**Consultation Response from Alan Smith,
KC Waste Strategy (Refuse & Recycling)**

2026/91599 Wesley House, Huddersfield Road, Birstall, Batley, WF17 9AZ

Discharge of details reserved by conditions 3 (roof light), 8 (bin store), 9 (lighting), 10 (bat box), 11 (Construction Management Plan - Gravestone) on previous permission 2024/92105 for alterations to convert former offices to 21 apartments (Listed Building within a Conservation Area)

Responding Ref: WPN 26 028

Drawing No: KL/24/1709/21	Scale: 1:50 @ A1	Date: July 2025
------------------------------	---------------------	--------------------

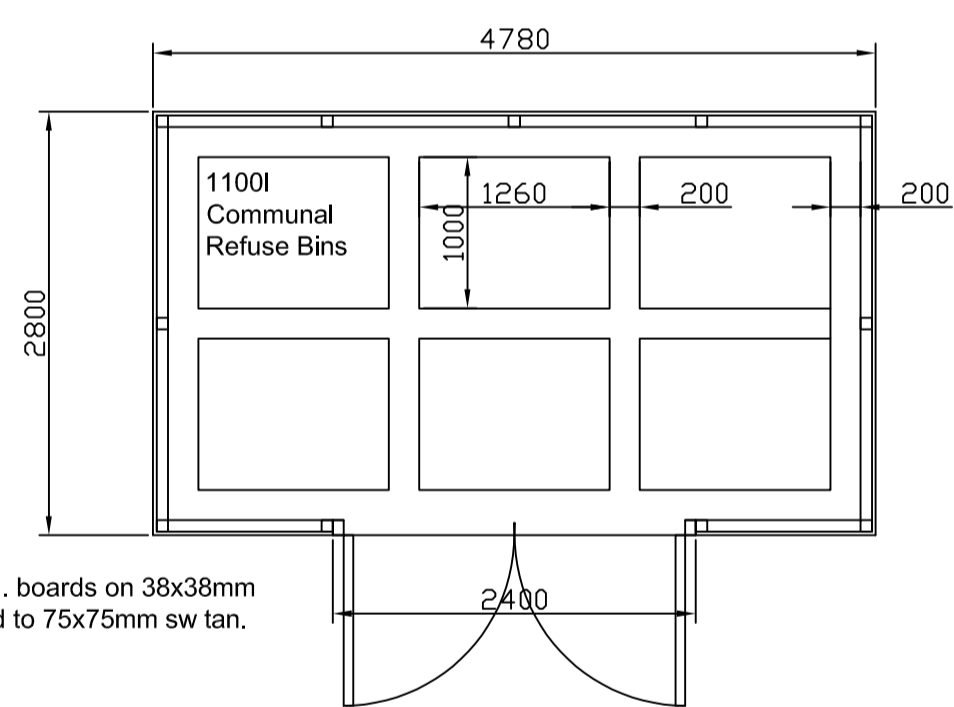
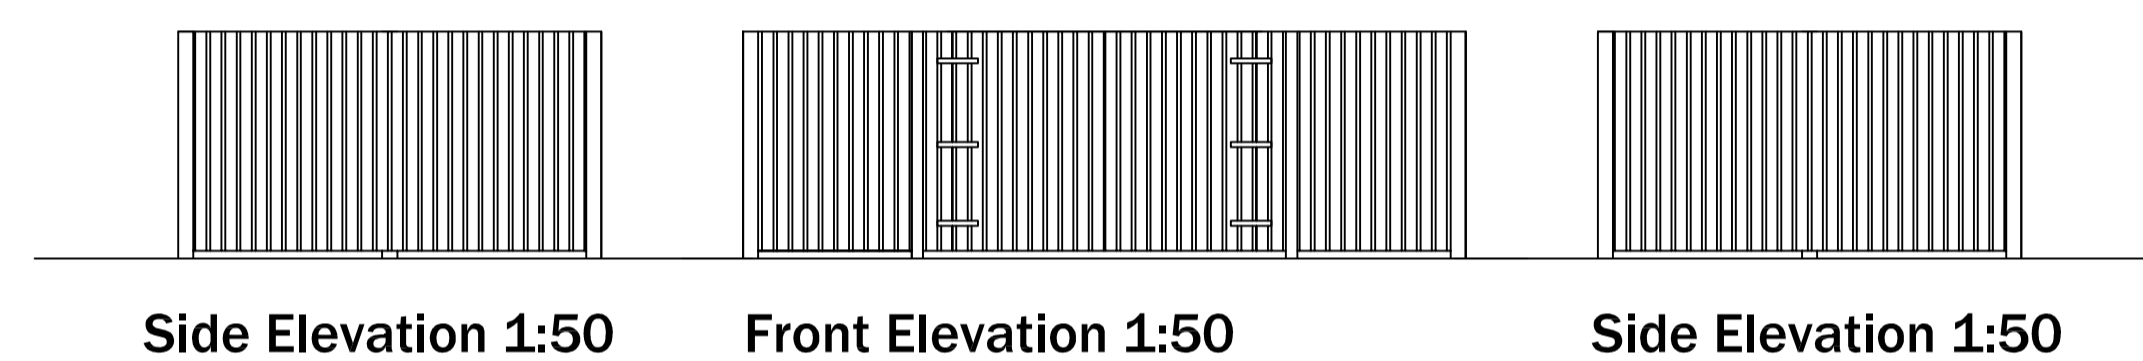
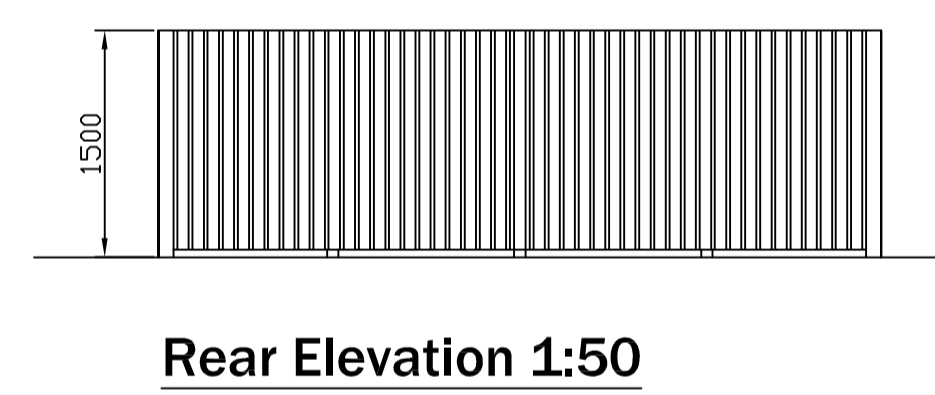
The bin store shown on the plan is undersized, as noted in a previous response. Each 1,100L bin requires a footprint of approximately 1575 mm x 1190 mm. Adequate space must be provided to ensure bins are easily accessible for both residents and refuse collection crews. Bins should be well spaced and not positioned in a way that obstructs access or movement, allowing for safe and efficient use.

Drawing No: **KL/24/1709/01C** Scale: **1:200, 1:1250 @ A1** Date: **July 2024**

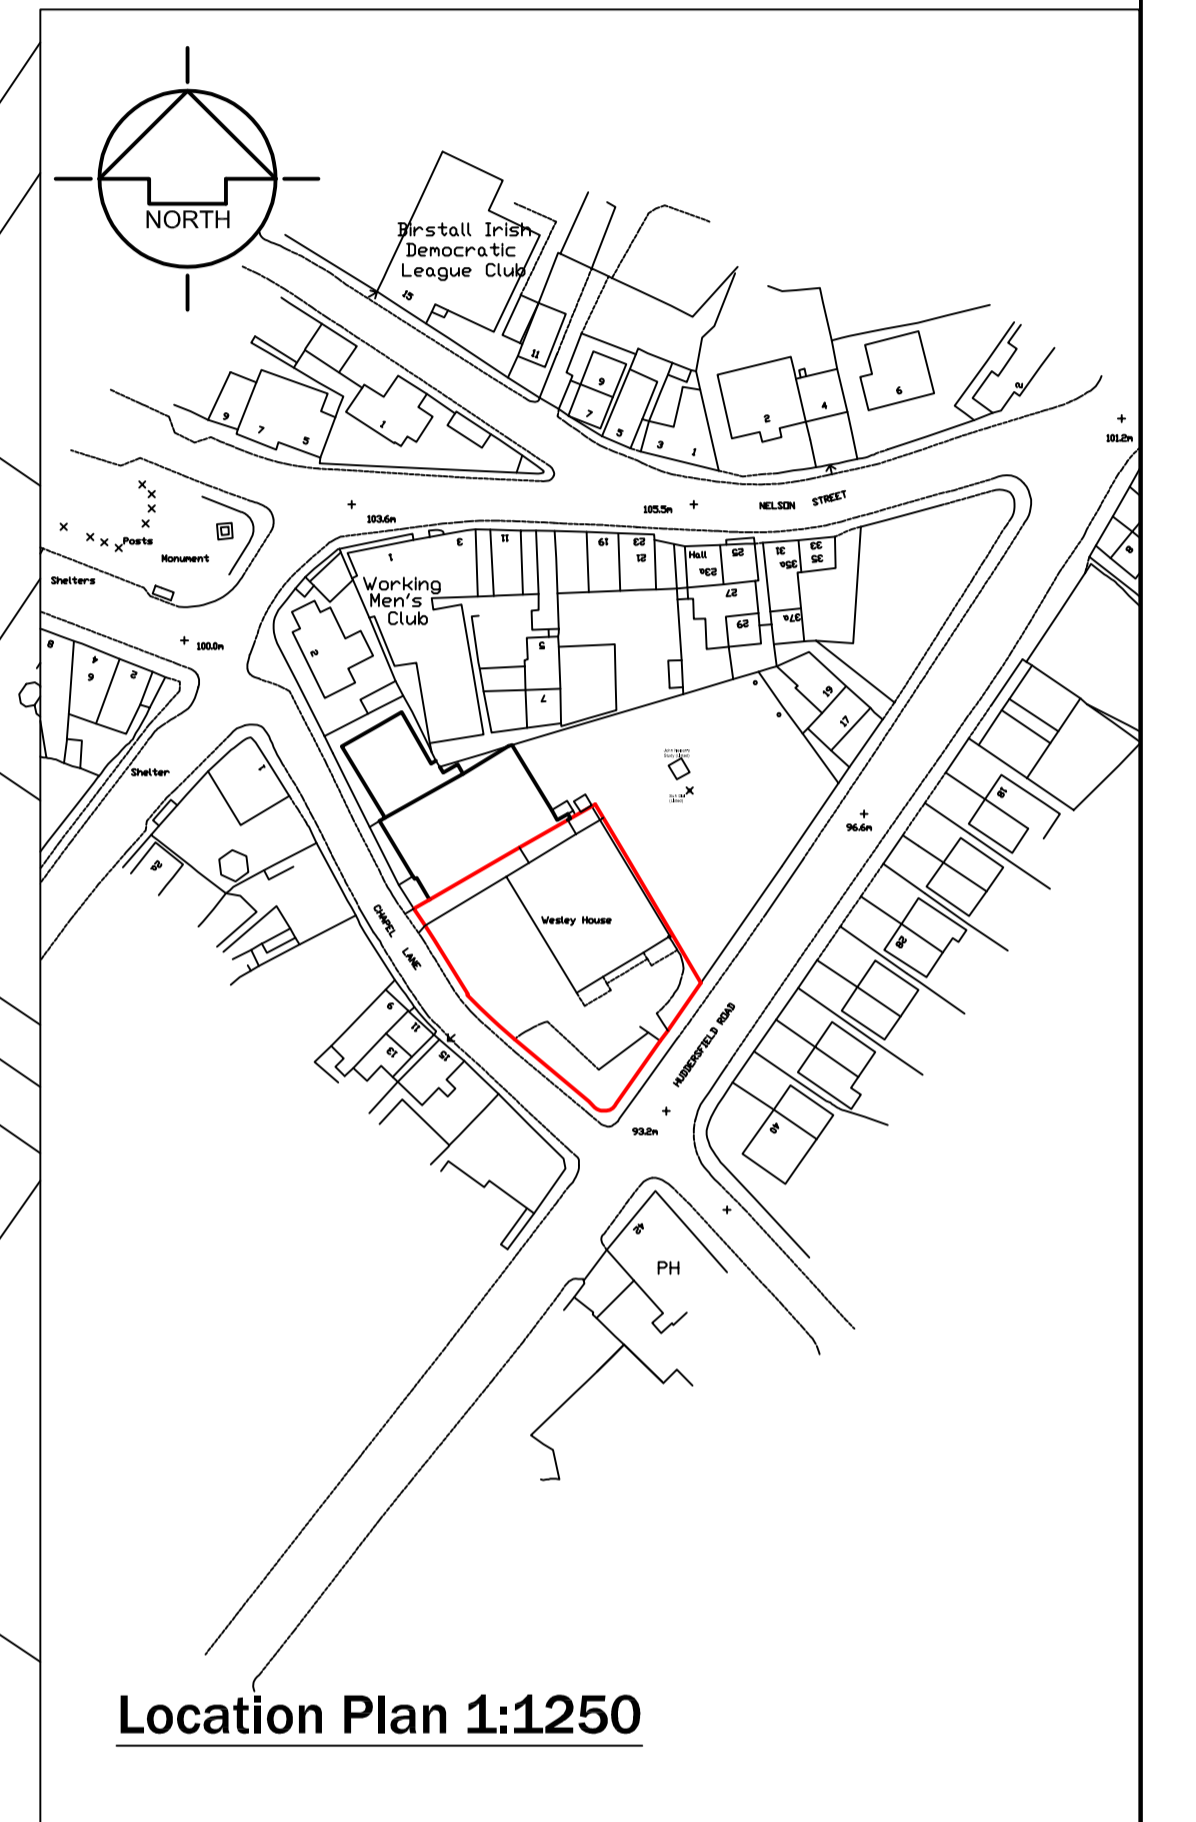
For Condition 8 the developer has submitted a drawing, "Proposed Site Layout and Location Plan", drawing No. KL/24/1709/01C.

Given the information provided by the developer the WCA cannot agree to the Discharge of Condition 8 for the site for several reasons.

1. Bin store size:

2. Bin store location:

The proposed bin store is located too far from the adopted highway. It was previously recommended that the bin store be repositioned closer to the highway, for example within car parking space '7'. The bin store should be located within 8 metres of the adoptable highway to ensure safe and efficient collection. If this cannot be achieved, an alternative arrangement must be put in place whereby a management company is responsible for presenting the refuse containers at the highway boundary on collection day.

3. Slope to highway:

The proposed site entrance is excessively steep and unsuitable for the safe manoeuvring of bins. There is also a risk of the refuse collection vehicle grounding when entering the site. The gradient must not exceed 1:12, as steeper slopes present a significant risk of bins becoming unmanageable and rolling away from operatives, potentially causing injury or damage. The previous layout demonstrated a bin store positioned on the opposite side of the car park, where the gradient was less severe and more acceptable; this arrangement should be reconsidered.

Access between the bin store and the highway must be provided on a gradient of no greater than 1:12 to ensure safe and compliant operation.
